APPLICATION FOR AMENDMENT TO PERMIT

Amendment No. ONE
Portland, Maine, 4/29/98

Location 6 Deepwood Drive (398-A-28) Within Fire Limits? _____ Dist. No. _____
Owner's name and address Richard Kelley Telephone 878-8166
Lessee's name and address _____ Telephone _____
Contractor's name and address Dave Dardano, West Lynn ST., Portland Telephone 878-3922
Architect _____ Plans filed _____ No. of sheets _____
Proposed use of building no change No. families _____
Last use _____ No. families _____
Increased cost of work 450.00 Additional fee 25.00

rear steps

REAR PLAN VIEW

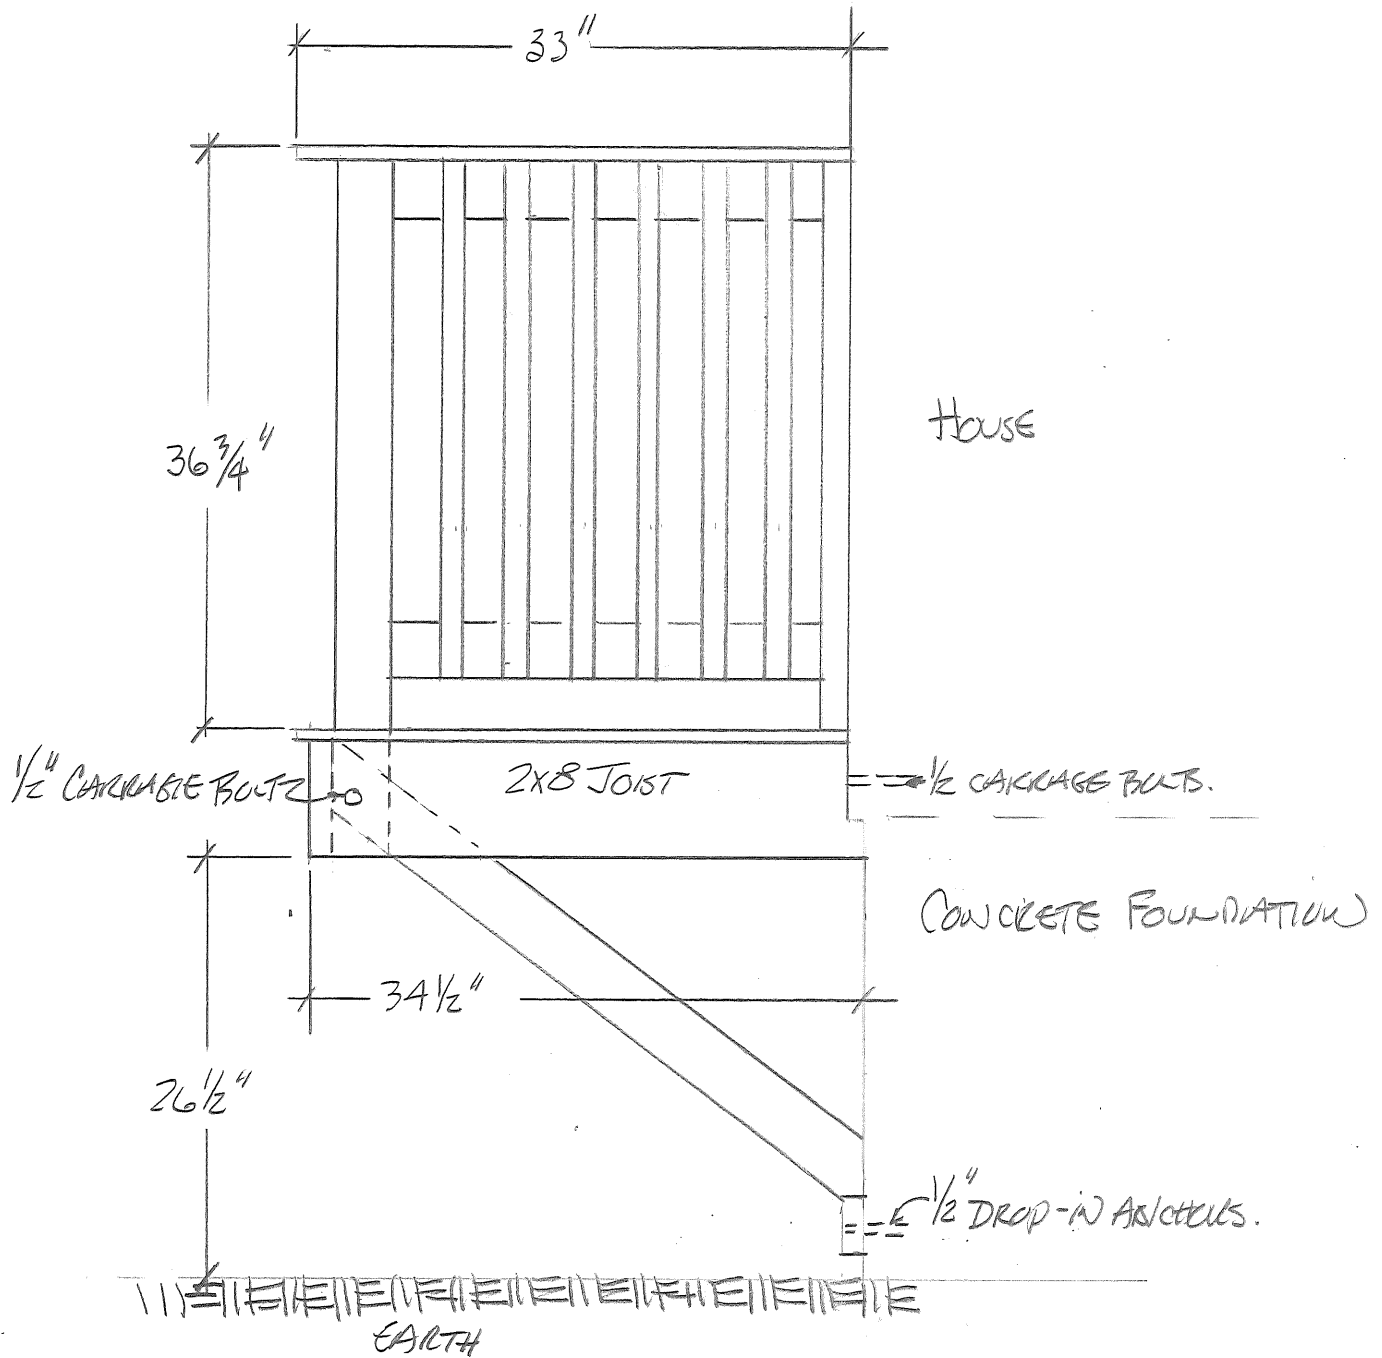
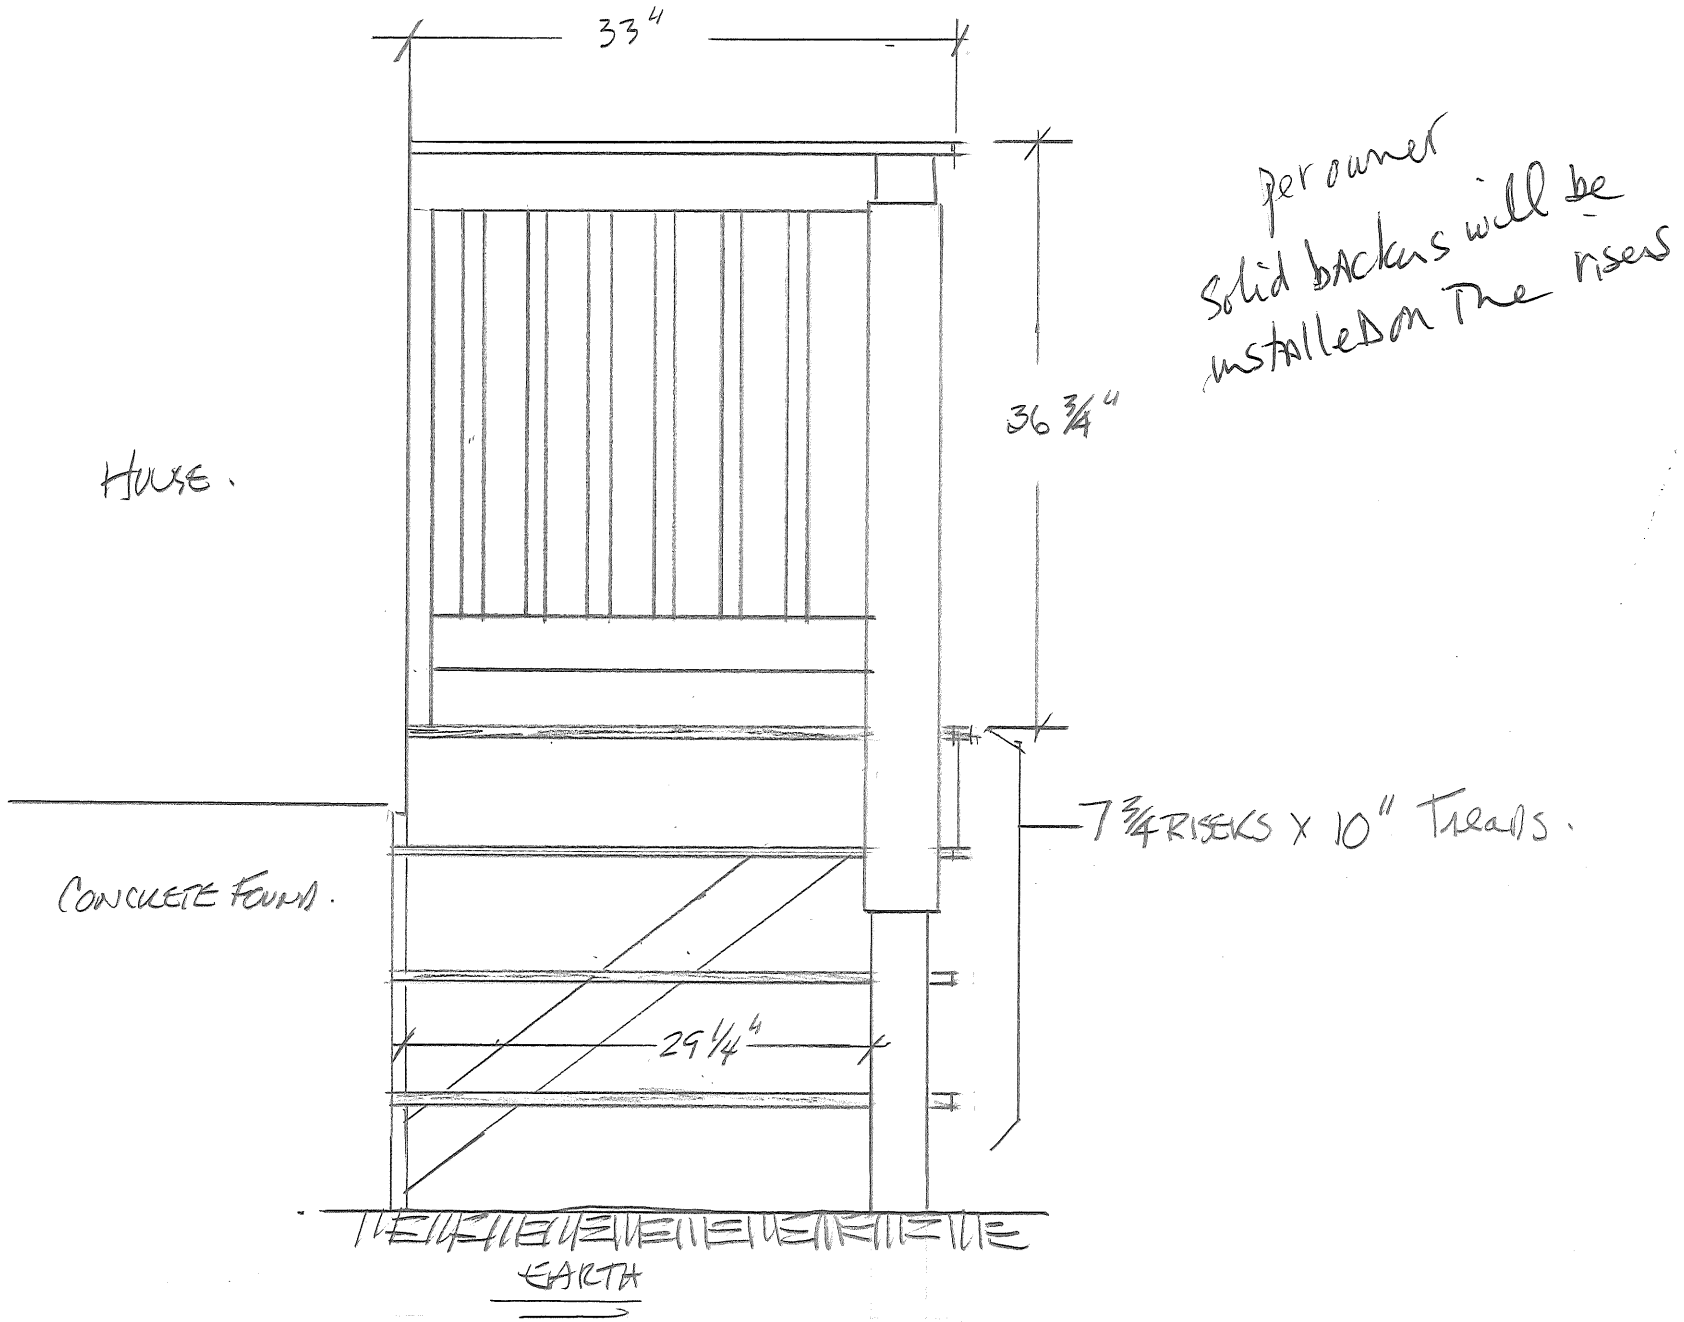
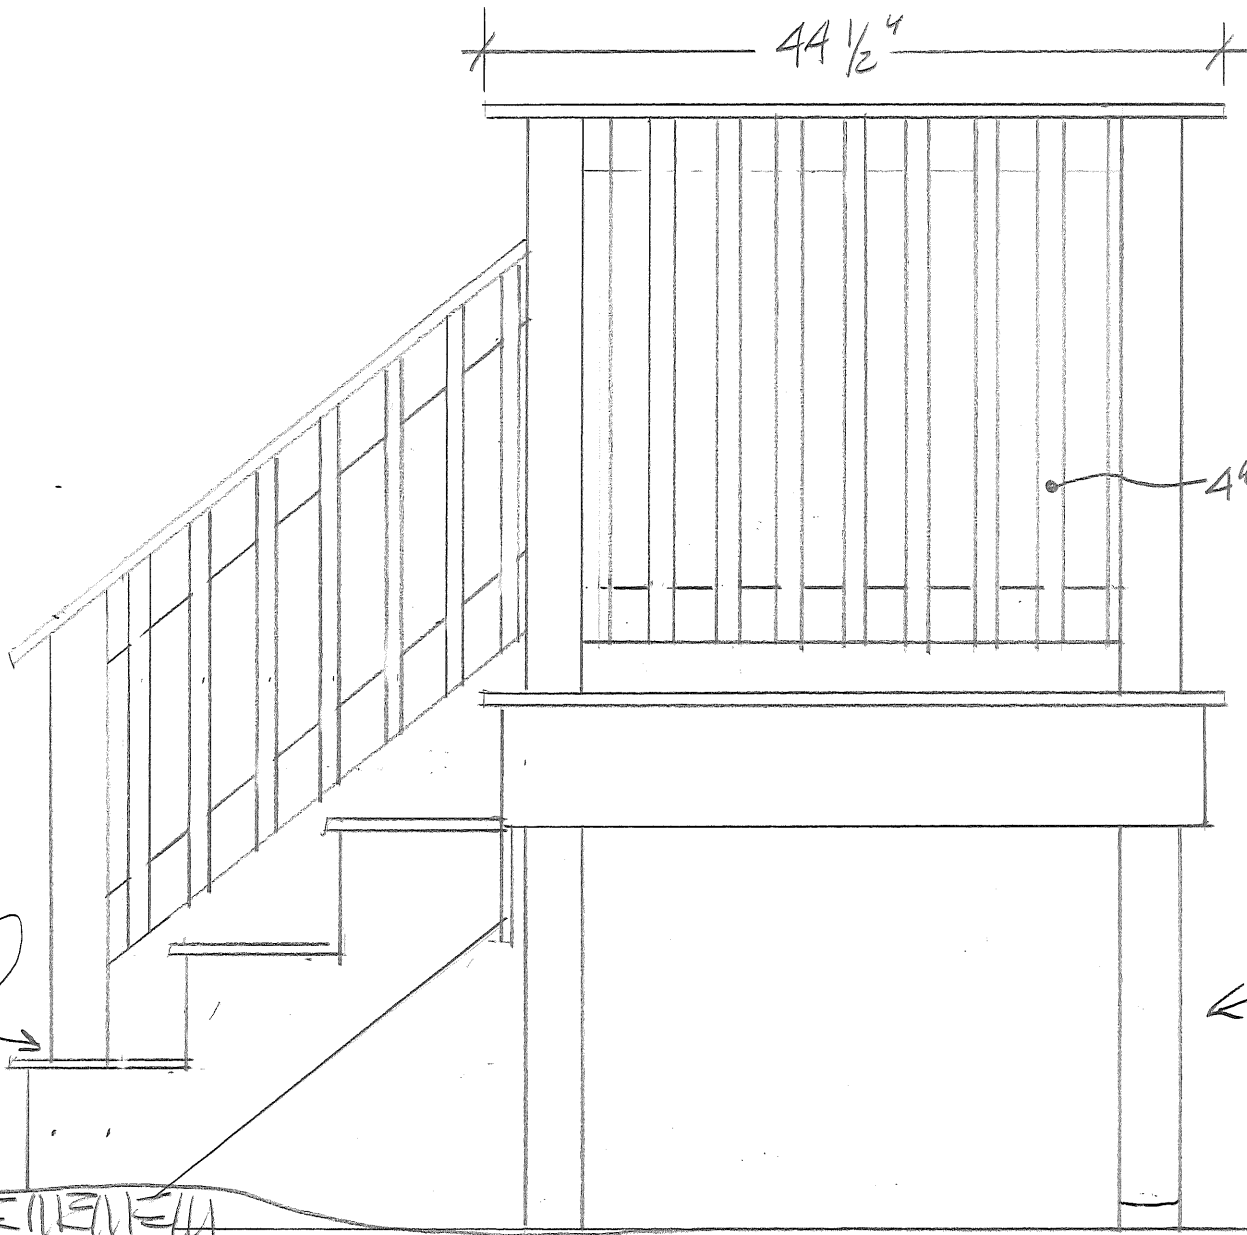
Approved: OK - using Sec 14-425 which allows a 2' sill overhang into a required yard - This method of construction shows the sill overhanging
Signature of Owner
Approved: _____ Inspector of Buildings
